**Consultation Response from KC,
Highways Development Management****2023/91264 67-71, Northgate, Cleckheaton, BD19 3HZ****Conversion of first floor offices to six flats including associated external alterations****Date Responded: 28/06/2023.****Responding Officer: D. Stainsby****Responding Ref: K9-3SE/1**

SITE PLAN

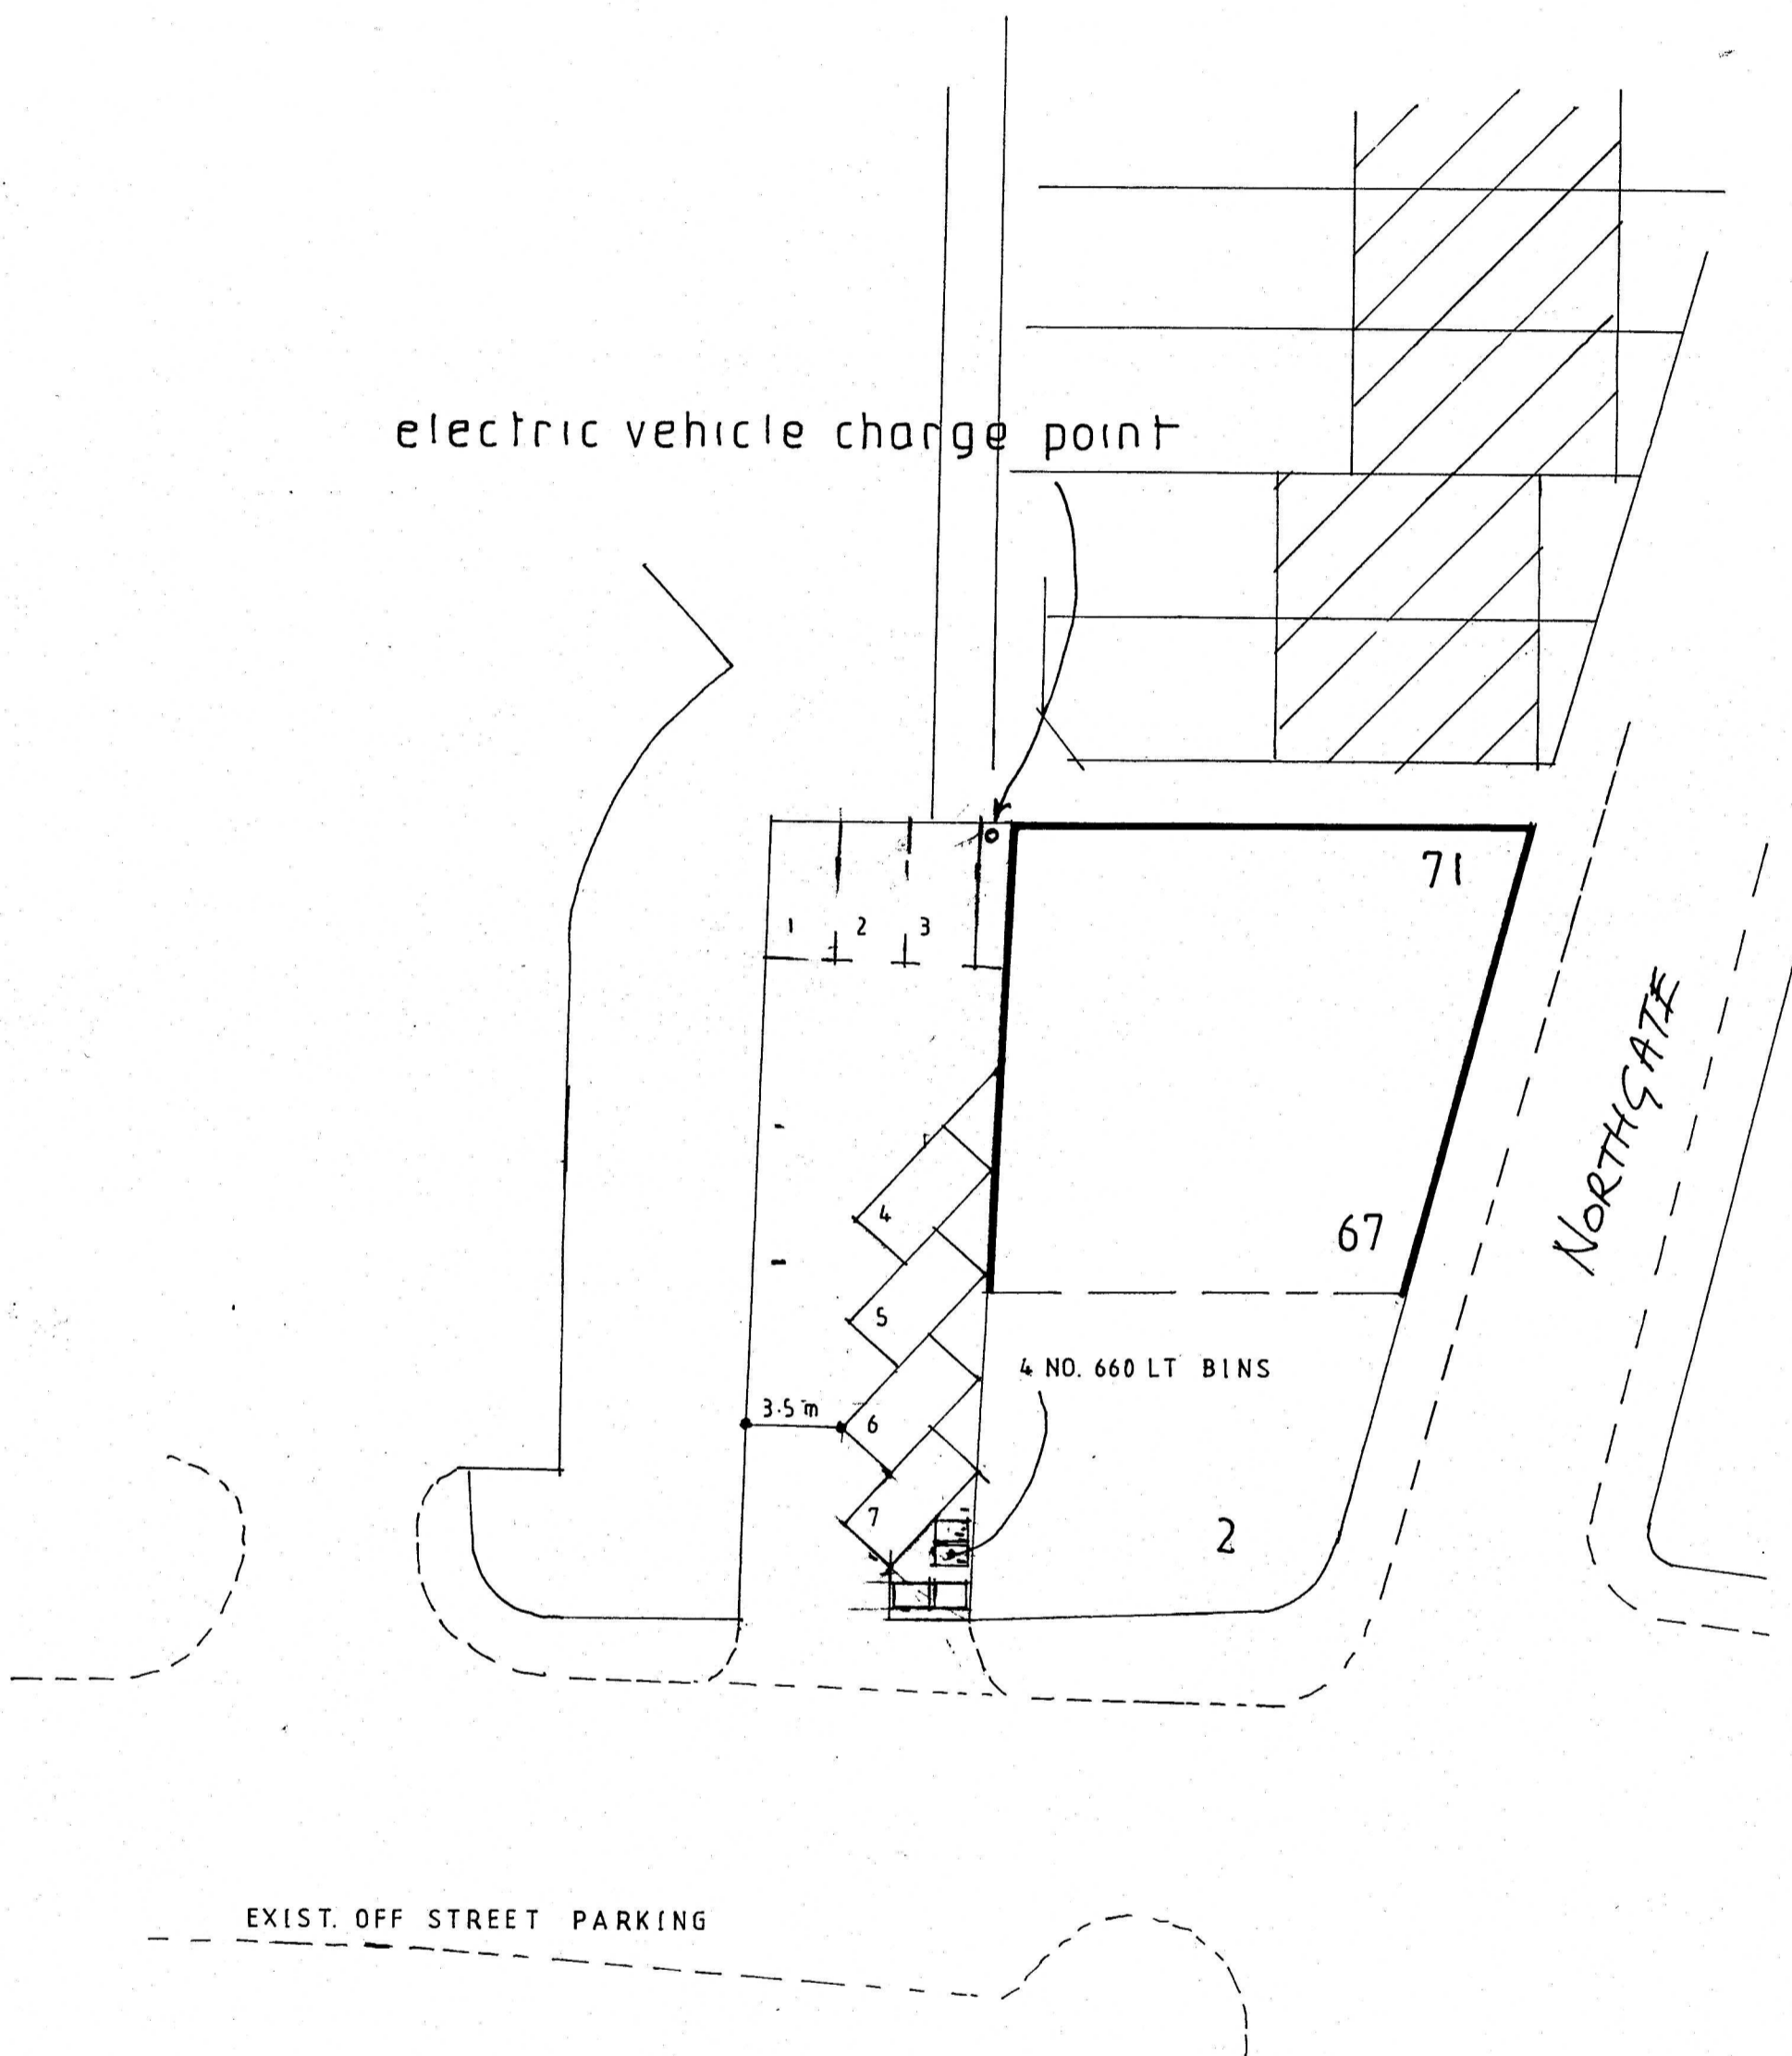
Clarification of the existing and proposed use of the car parking area is required.

The layout of the car park is substandard and does not have sufficient turning space to allow for vehicles to enter /exit the site in forward gear.

Notwithstanding the above comments, however, it appears that the car parking area is already being fully used by tenants of the property and adjacent residents meaning that either there is no provision available for the proposed flats or the existing office users' vehicles will be displaced elsewhere,

Either way the applicant needs to clarify the existing and proposed parking arrangements.

The proposed bin storage area appears to be for the proposed flats only and does not show the bins for the existing offices and/or the adjacent dwelling. I assume that the offices and adjacent dwelling also use this area for the storage of their bins and, as such, the area shown will not be large enough to accommodate all the bins required.

The proposed location of this bin store is also greater than the recommended minimum distance of 8m from the bin store to the adopted highway.

A bin collection/presentation point should be located adjacent to the public highway. The bin collection/presentation point must not obstruct the adopted highway or the car park access road.

Details of waste storage and collection for both the existing offices, adjacent dwelling and proposed flats should be provided, with the location of a waste collection presentation point being clearly marked on a drawing in such a location that is easily accessible to the collection team and where it will not obstruct the parking, access, or the adopted highway for road safety reasons.
